Your Ref: OWPC15417
Our Ref: R/184/17/PD 08-08-2017
Please ask for:
Mrs A Gardner

Notification for prior approval under class C for a change of use from a shop (Class A1)
to a restaurant/cafe (Class A3)
51 Sea Lane Rustington

**APPENDIX ONE:
DRAWING SHOWING EXTERNAL EXTRACT AND VENTILATION EQUIPMENT PROPOSED**

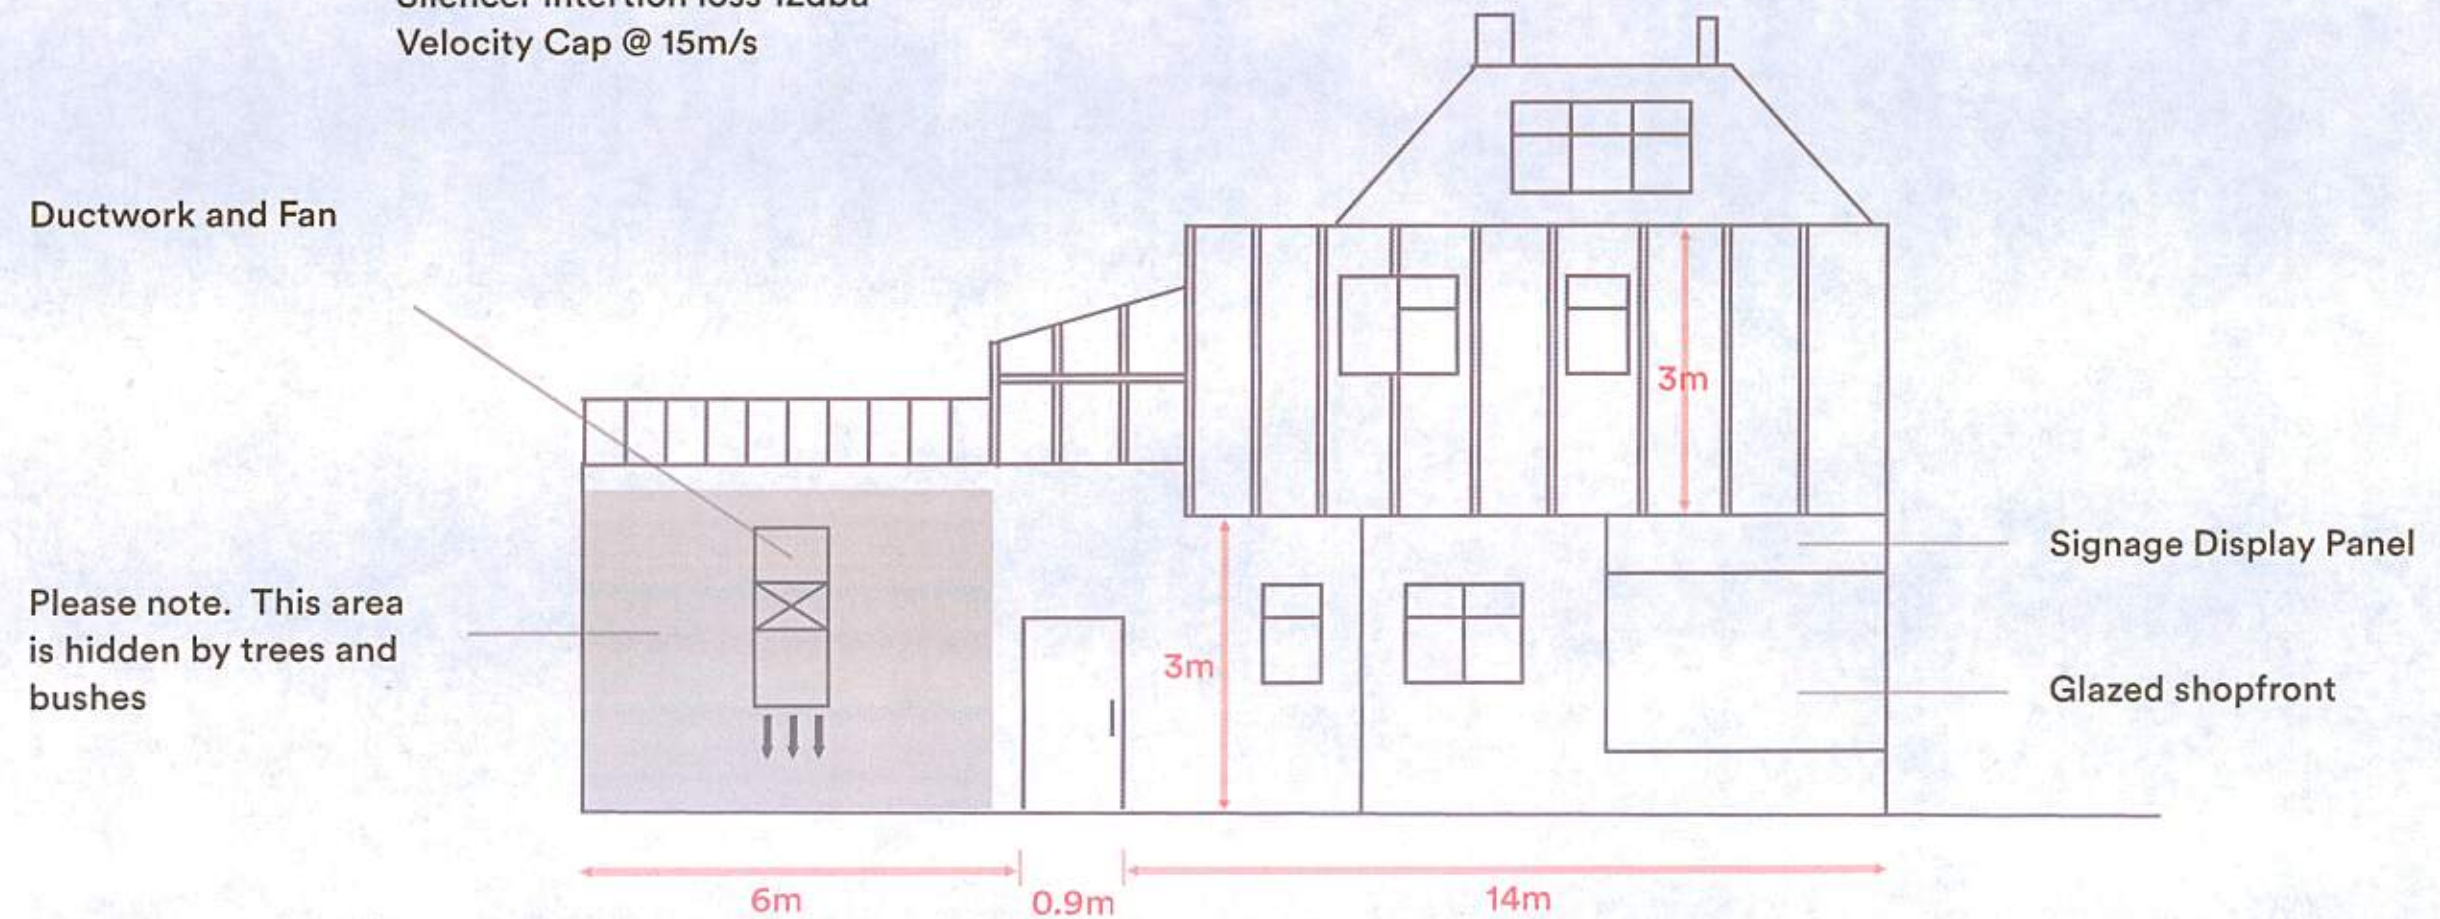
It will be very difficult to install the proposed ductwork and extractor fan without destroying the current foliage and if trees and plants have to be cut down to accommodate this work, the extractor fan will create noise, unpleasant smells and appear extremely unsightly for those whose bedrooms look out onto this area.

APPENDIX TWO:
DRAWING SHOWING PROPOSED REFUSE FACILITIES

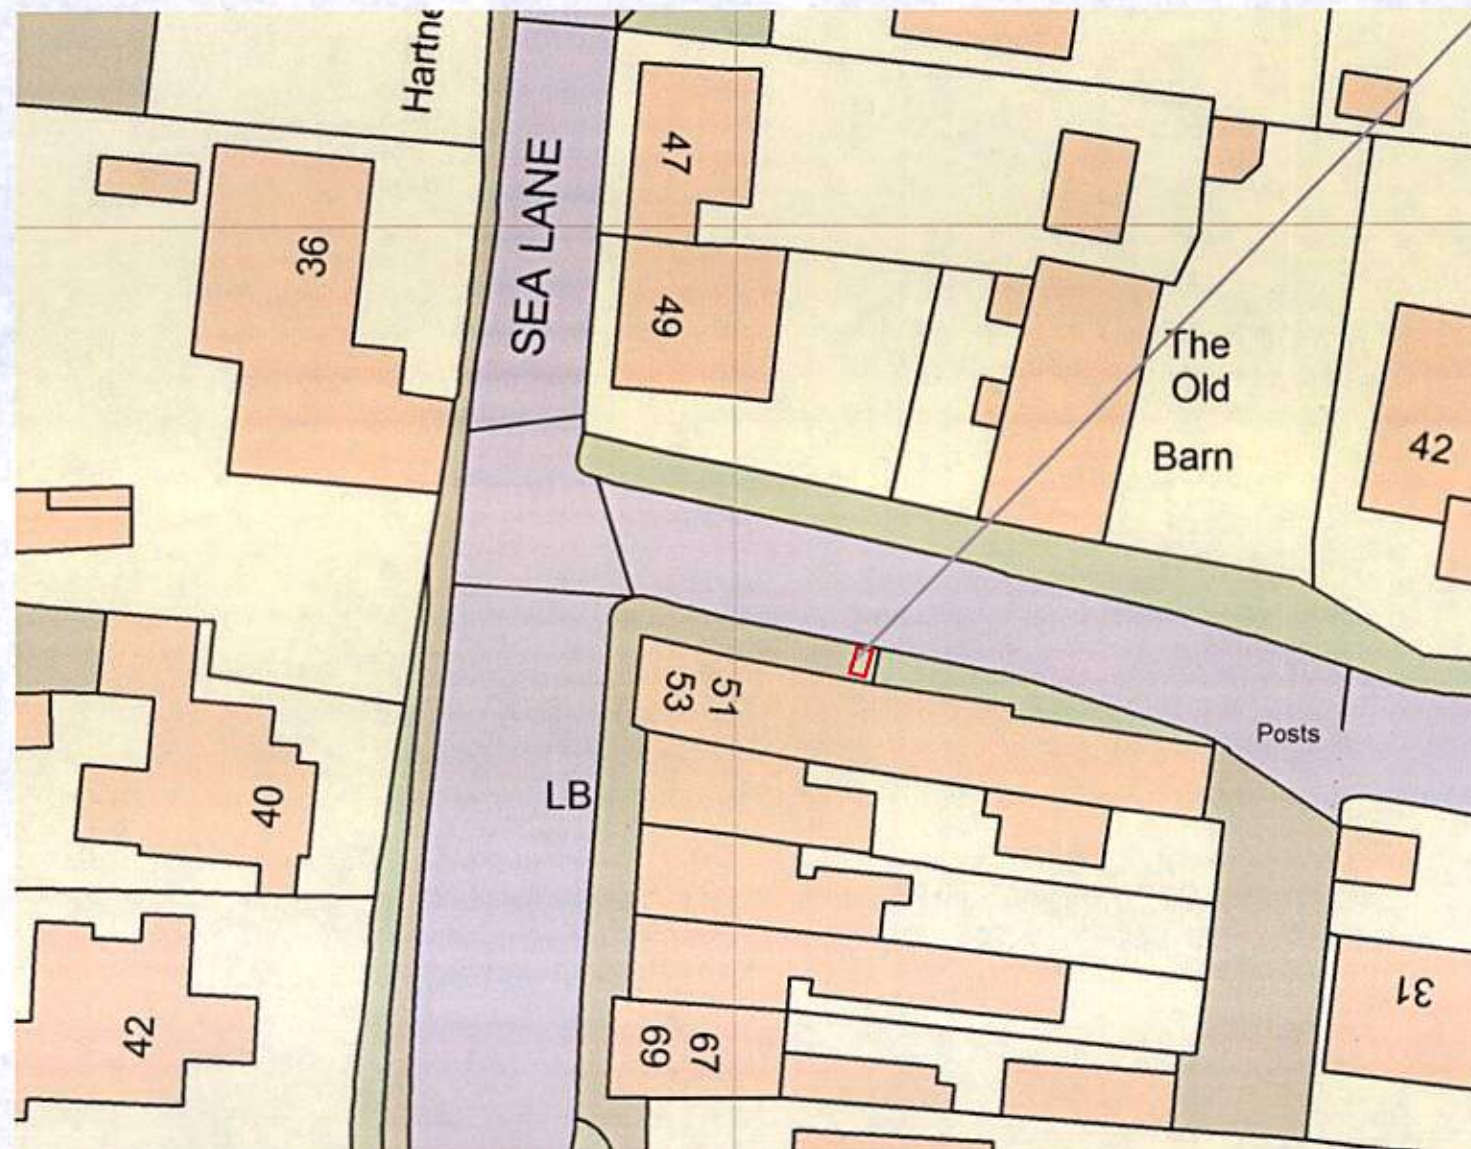
The proposed bin storage within the submitted plans is inadequate and not robust enough.
